FOUNDATION LUTHERAN CHURCH SUBDIVISION FILING NO. 1

A REPLAT OF TRACT C in PAINT BRUSH HILLS FILING NO. 13A, El Paso County, Colorado
being a portion of the West One-Half of Section 25, Township 12 South, Range 65 West of the 6th P.M.

SUBDIVISION PLAT
FOUNDATION LUTHERAN CHURCH
SUBDIVISION FILING NO. 1

SUBDIVISION PLAT
FOUNDATION LUTHERAN CHURCH
SUBDIVISION FILING NO. 1

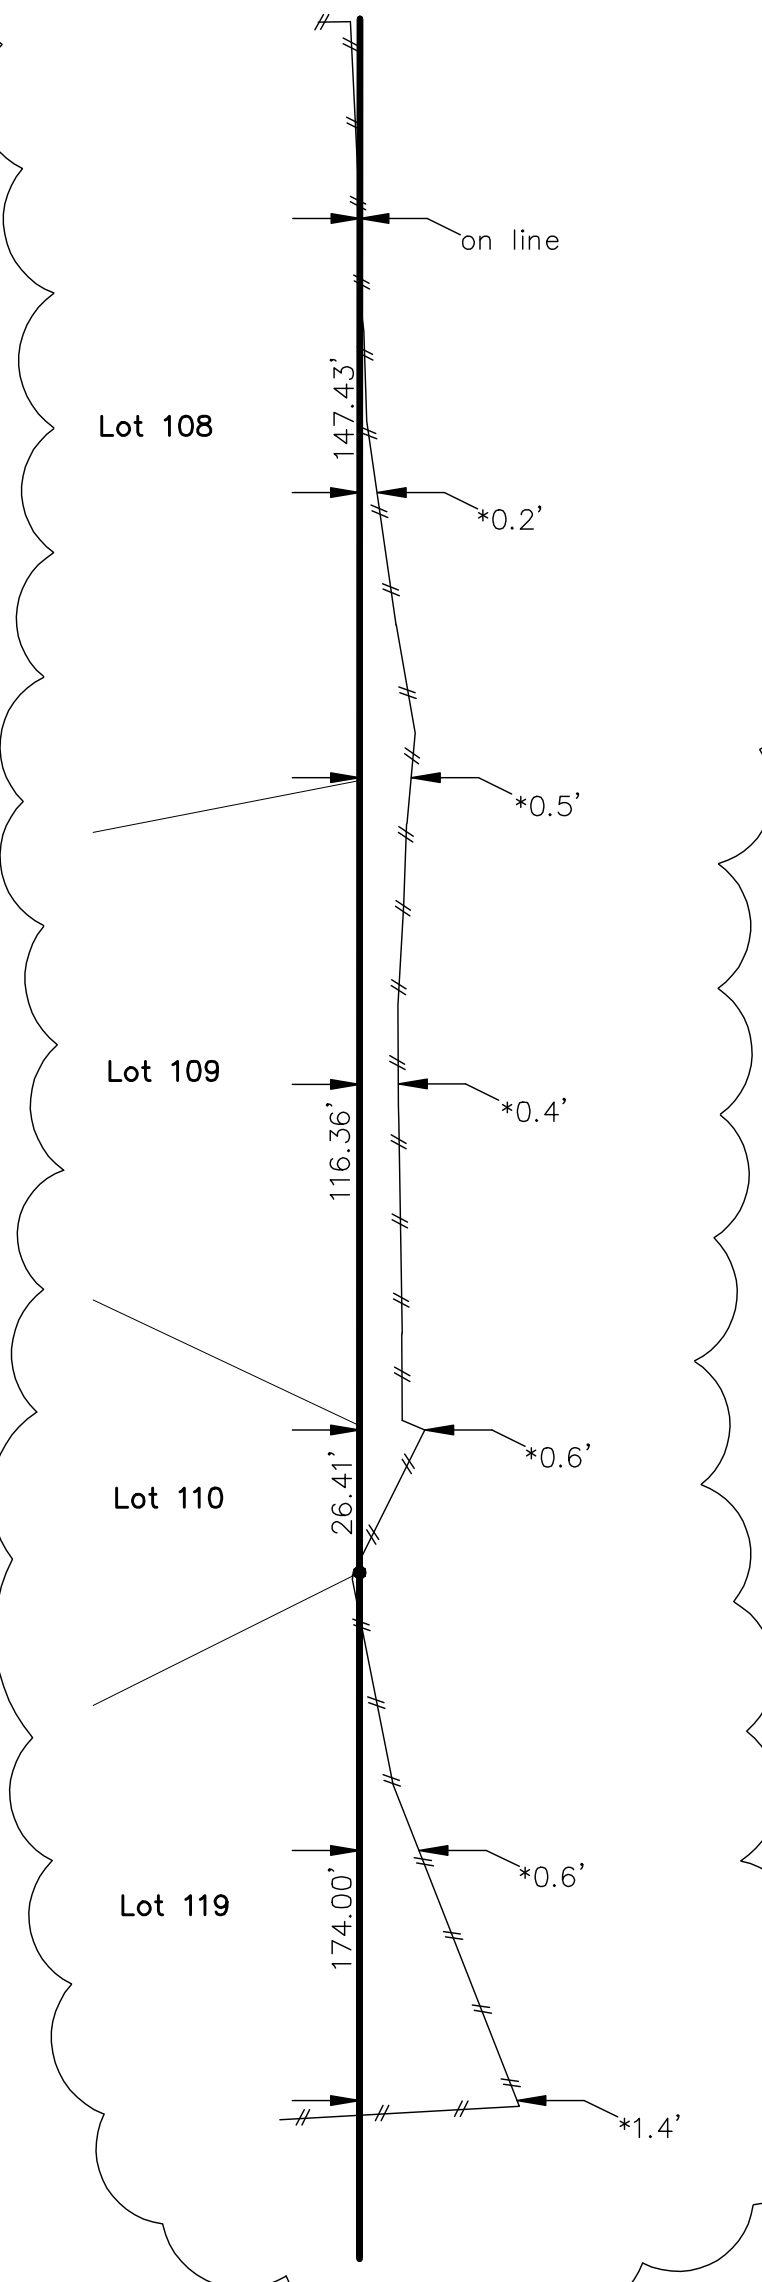
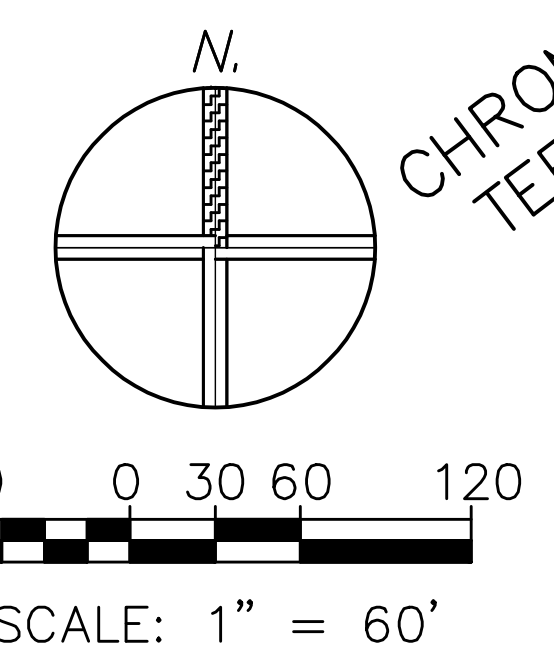
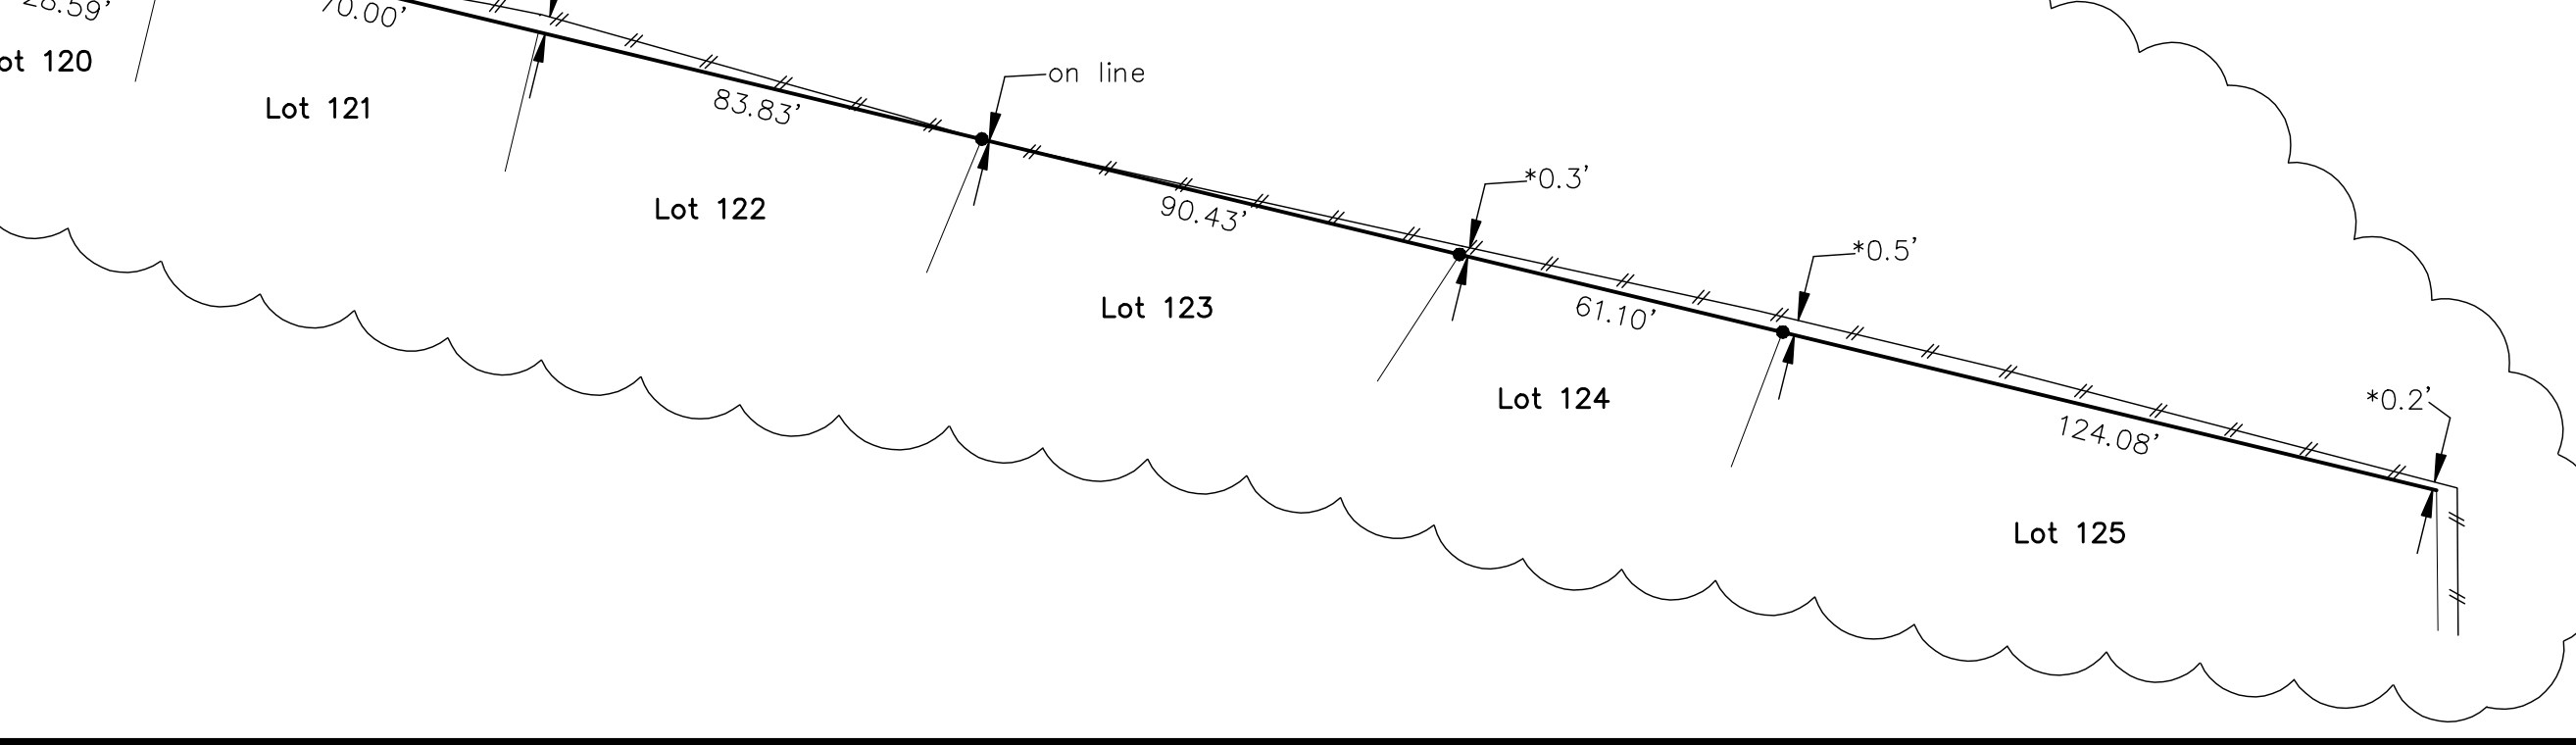
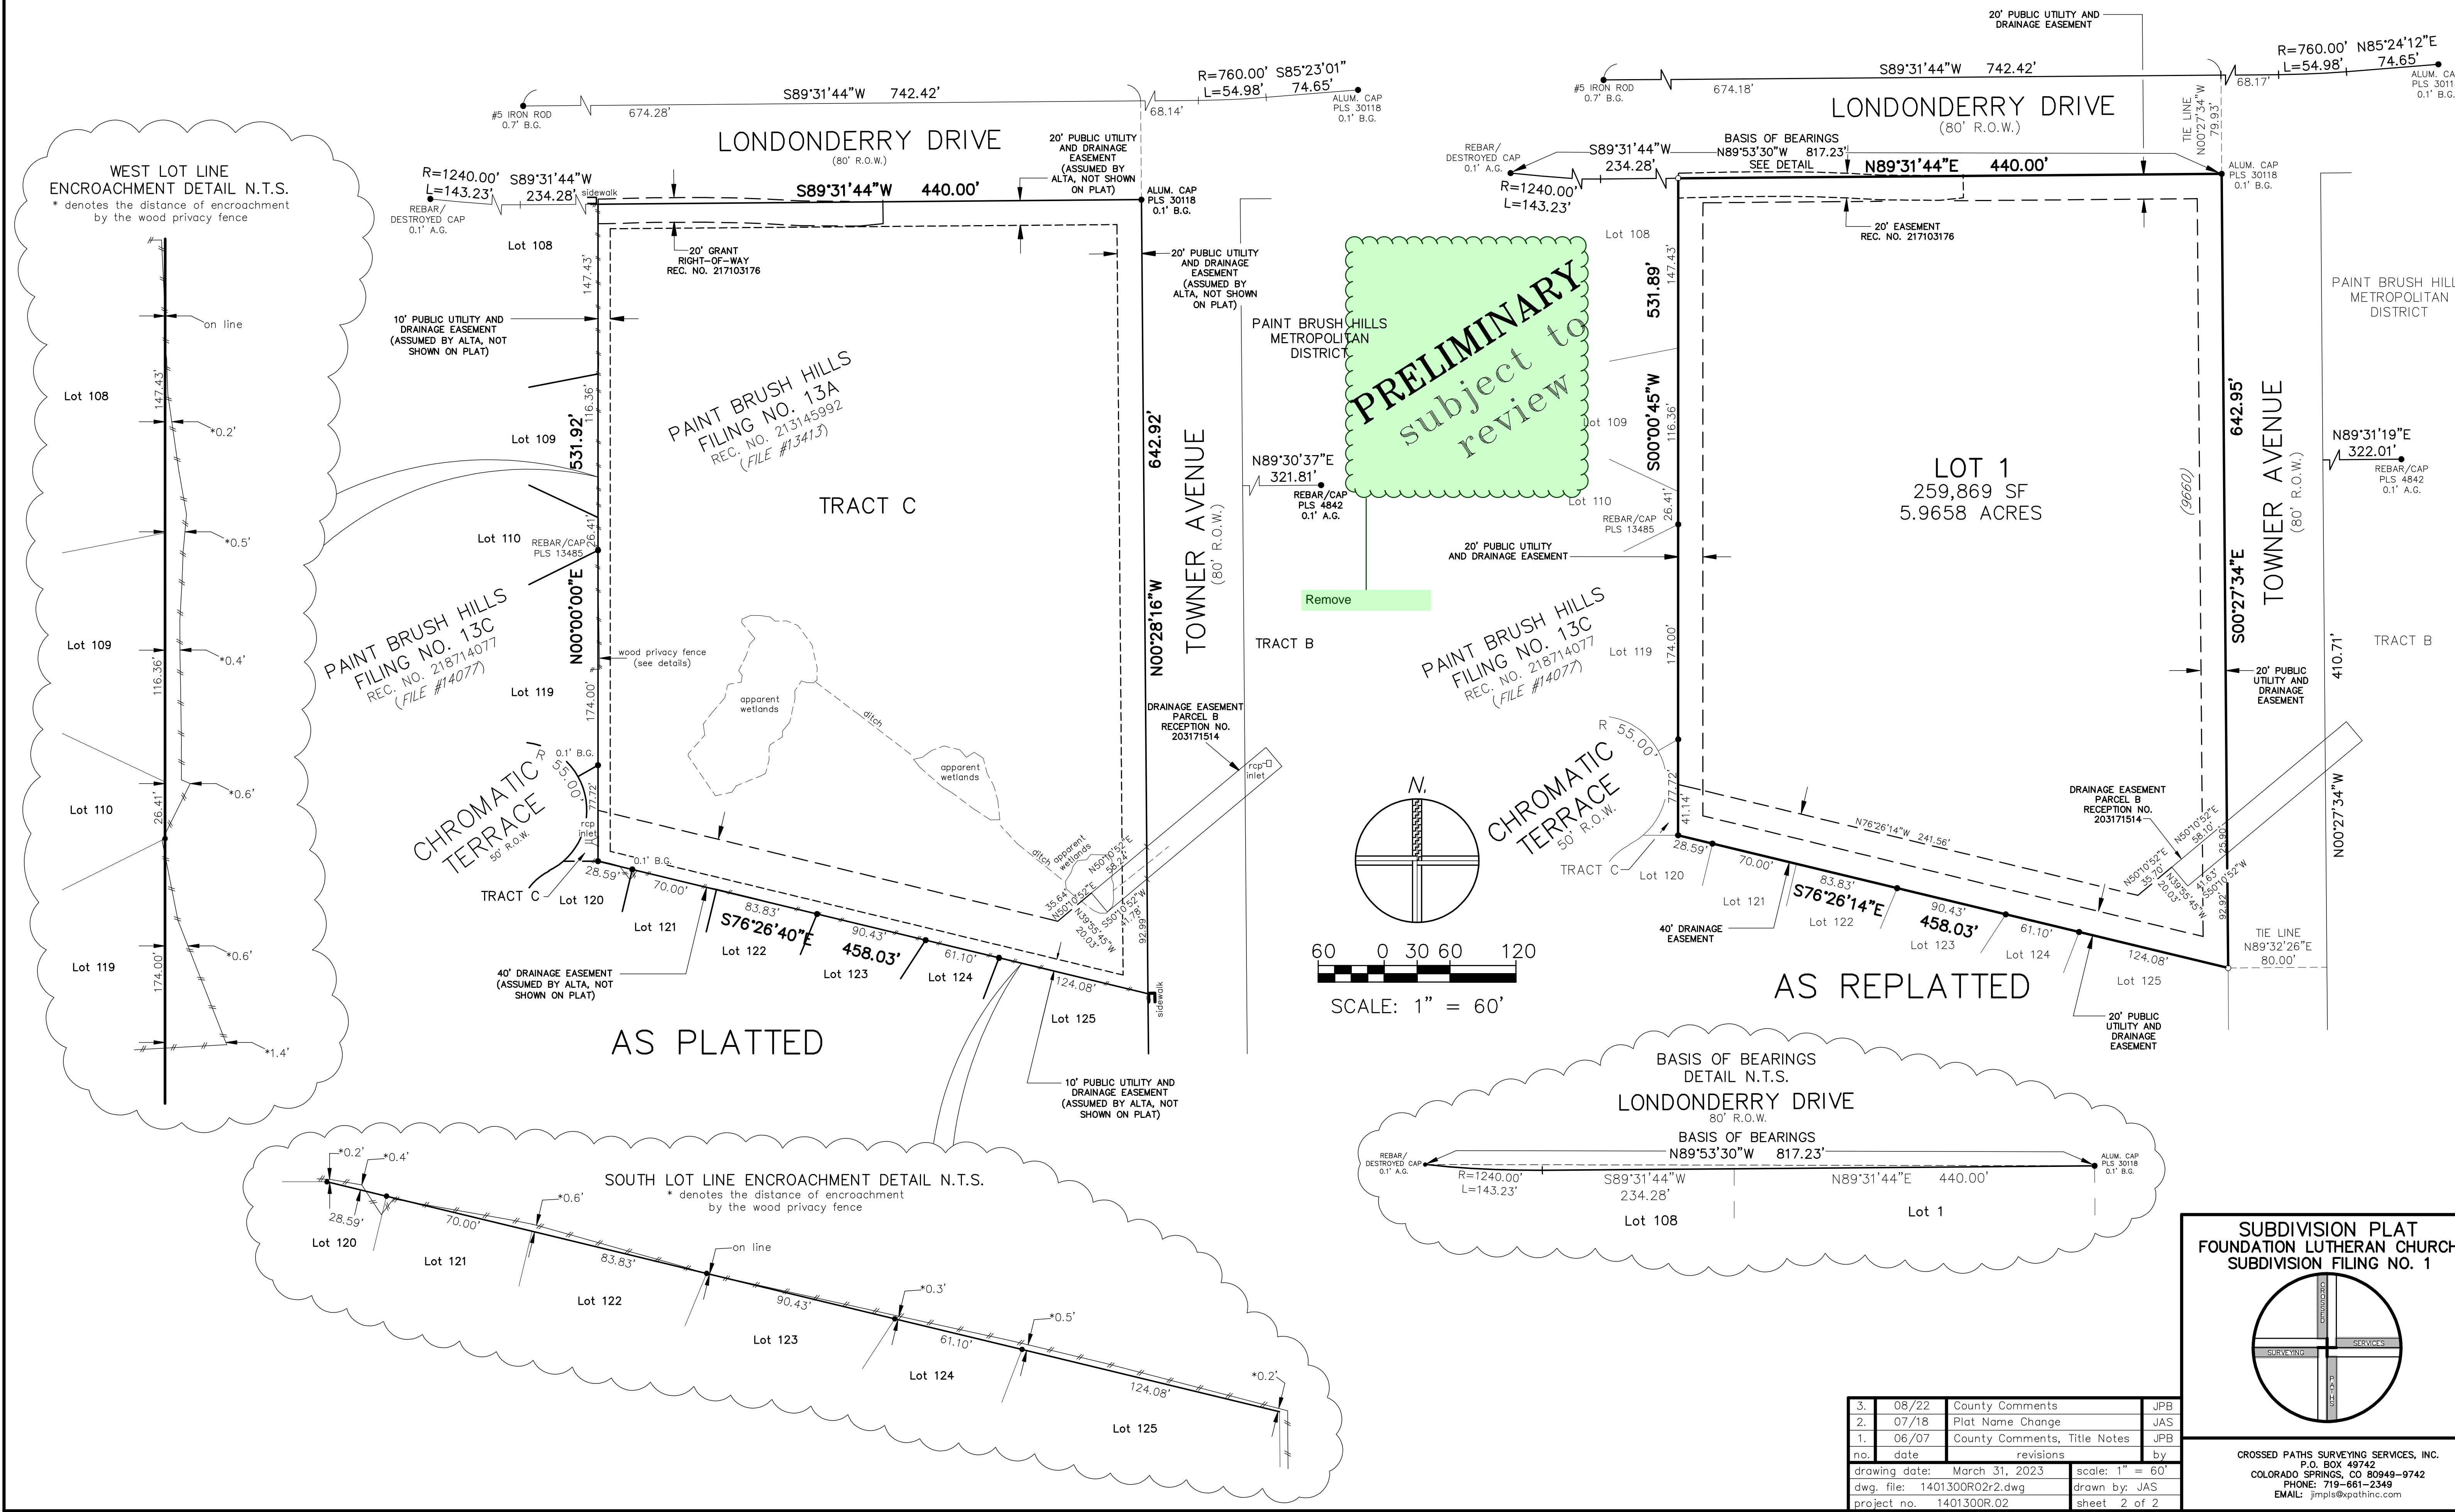
Relabel this as a utility easement. This is not public ROW. This is an easement to MVE per the recorded easement agreement.

Add all missing easement lines for the entire parcel on all sides
